Sussex Police
Serving Sussex

Local Policing Branch

Date: 16th October.2017

RE. Nyton Nursery, Nyton Road, Westergate, Aldingbourne, West Sussex.PO20 3UQ

General Site Layout Plan (Ground Floor)

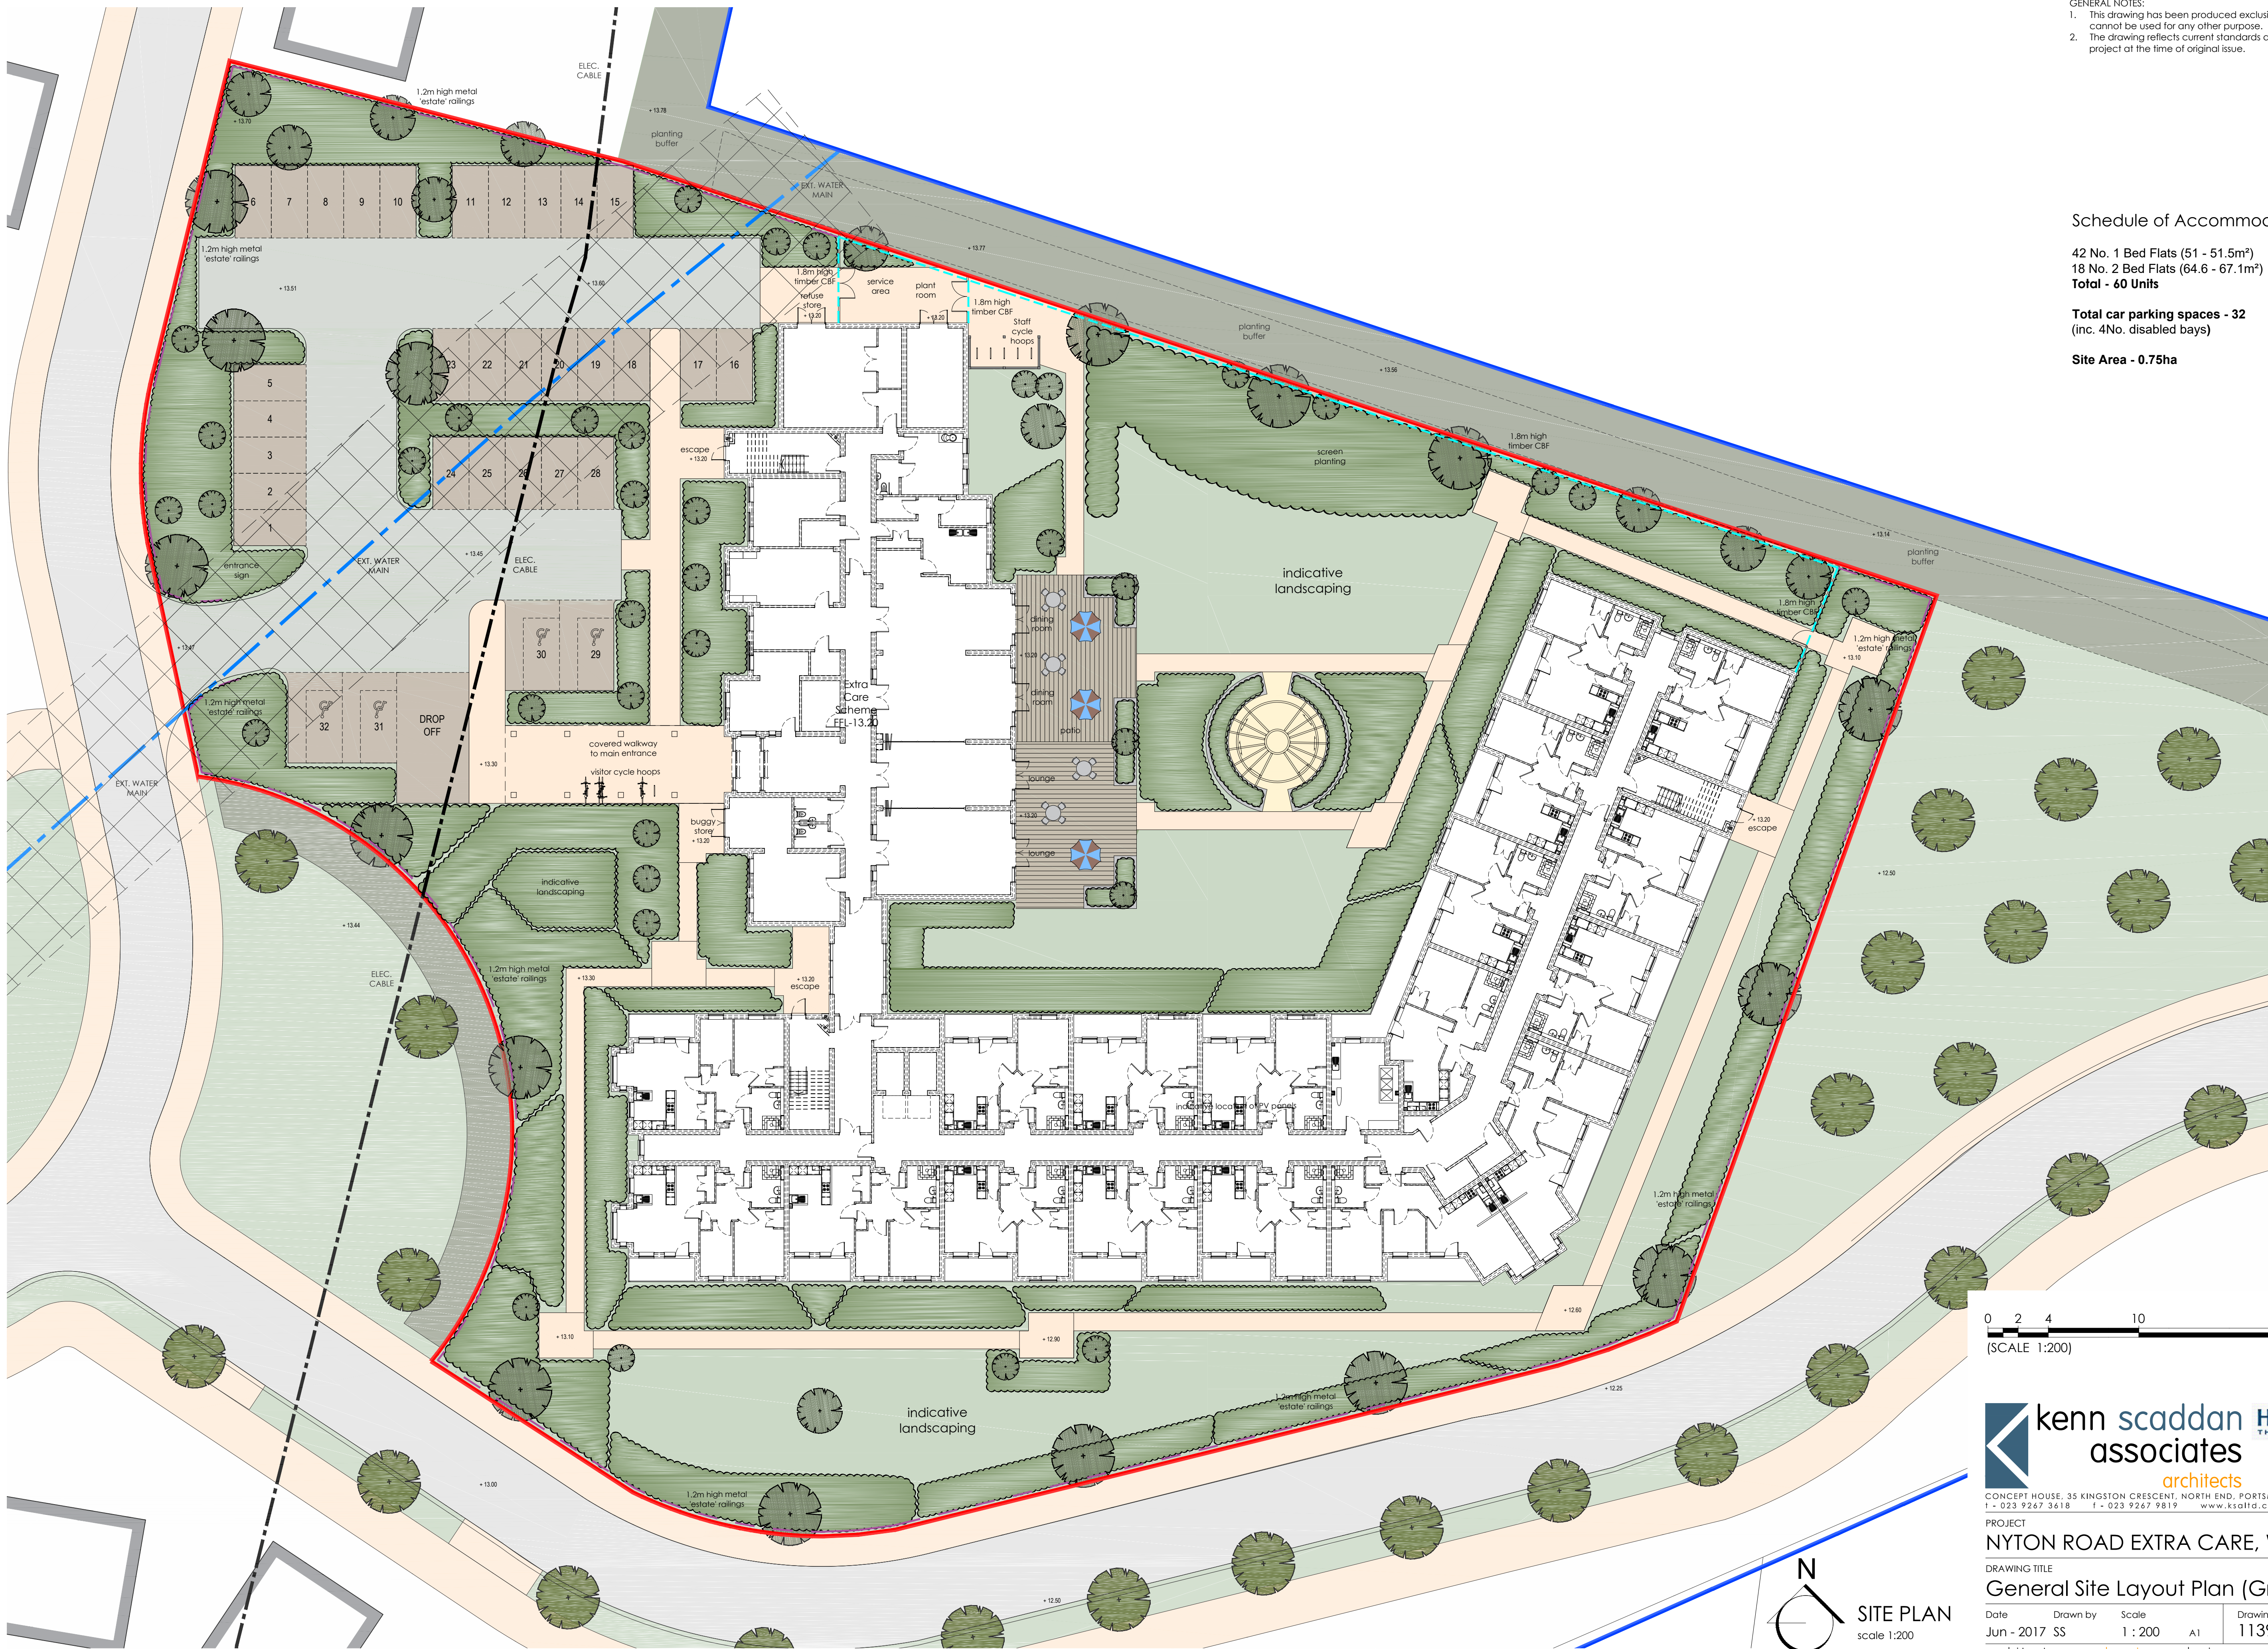
Street lighting through the development should conform to BS5489:2013. I would also recommend this standard for car park lighting at the 'Extra Care' Senior Living Home as bollard lighting may not provide sufficient facial recognition. On the housing development, parking bays outside flats, plots 92-99 and flats plots 208-207 should be illuminated as they are potentially vulnerable in recessed areas.

Extra Care Apartments located in the south east corner of the development will house vulnerable residents and so preventing unauthorised access to their private living accommodation is important with good access control and clearly defined separation between public and private areas.

I recommend the main front entrance doors conform PAS24:2012 or LPS 1175 SR and be fitted with swipe card access. Any glazed side panels to conform to BS356A .All other external doors should also meet PAS24:2012 or LPS 1175 SR specification

I would recommend CCTV that complies with the requirements of BS EN 62676:2014.be considered to monitor visitors to the apartments who access the building through the foyer.

Any access doors from public areas to residential areas must have access control. Especially from the foyer to the private residential corridors stairwells and lift lobby from the ground floor.

Minimum lighting specifications should include dusk to dawn switched lighting around the covered walkway, the external entrance and internal foyer. Stair wells and stair cases should also be fitted with either dusk to dawn lighting or PIR activated switched lighting.

I would recommend cycle stands should be of Sheffield hoop style of galvanised steel bar construction of at least 3mm thickness.

Title Play Strategy
Central Public Open Space

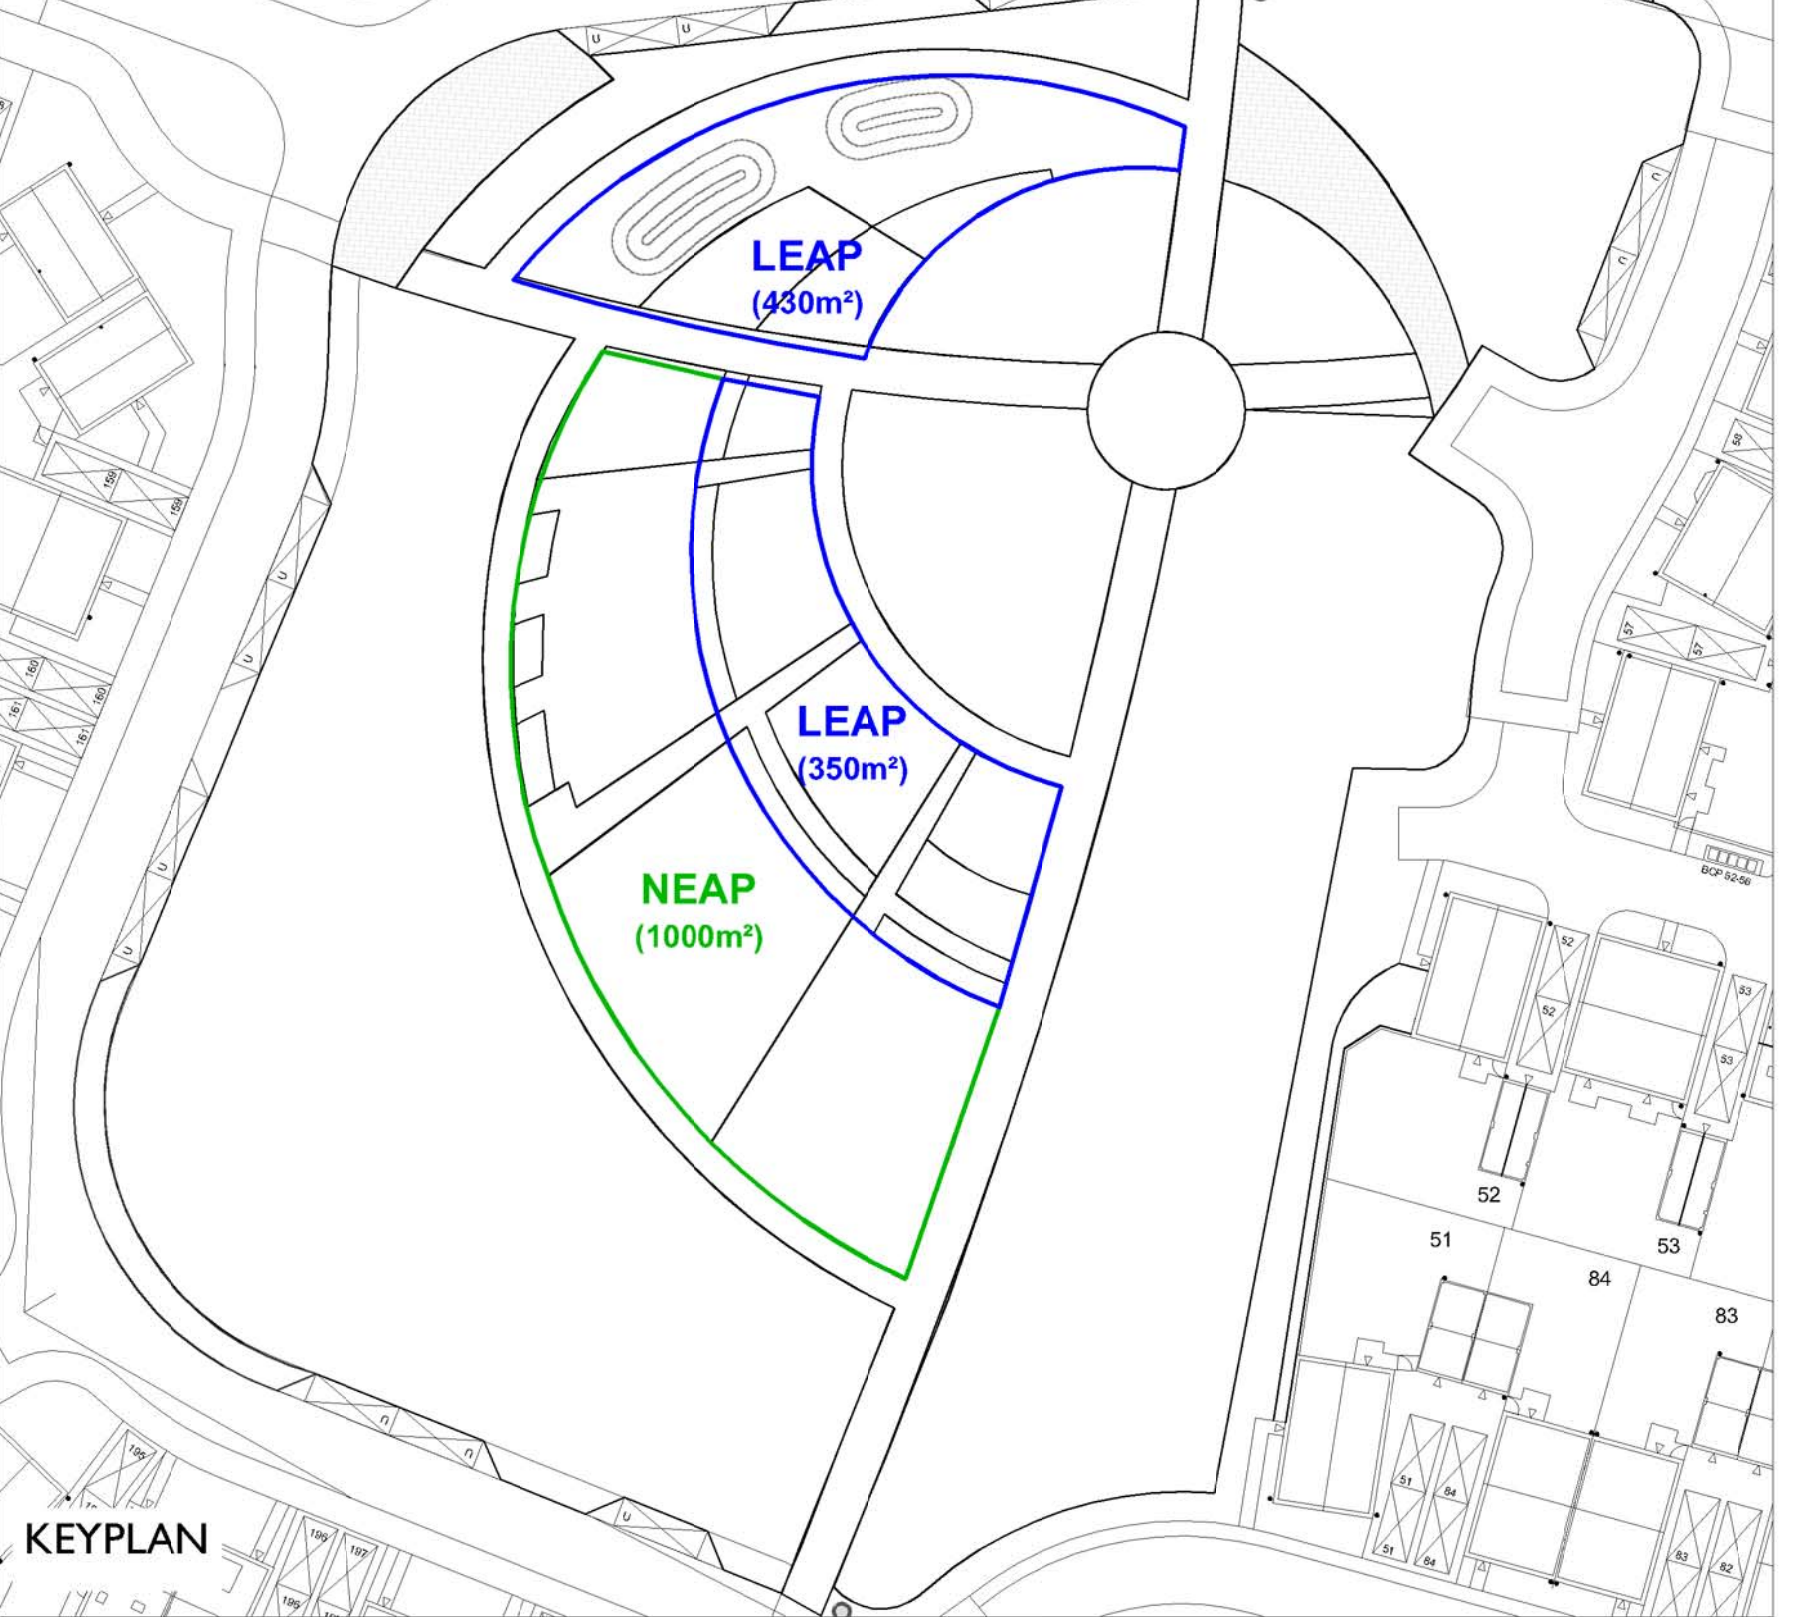
Areas of play should be situated in an environment that is stimulating and safe for all children, be overlooked with good natural surveillance to ensure the safety of users and the protection of equipment, which can be vulnerable to misuse.

I would recommend that the location is surrounded with railings with self-closing gates to provide a dog free environment.

I was pleased to see the Local areas of play and Neighbourhood areas of play have been located in good view of nearby housing. It will be necessary to keep foliage low in order to maintain natural surveillance throughout. Leisure areas including Local Areas of Play, Local Equipped Areas of Play and Neighbourhood Equipped Areas of Play require careful consideration when selecting their location. The National Playing Fields Association has recommendations for particular areas of choice.
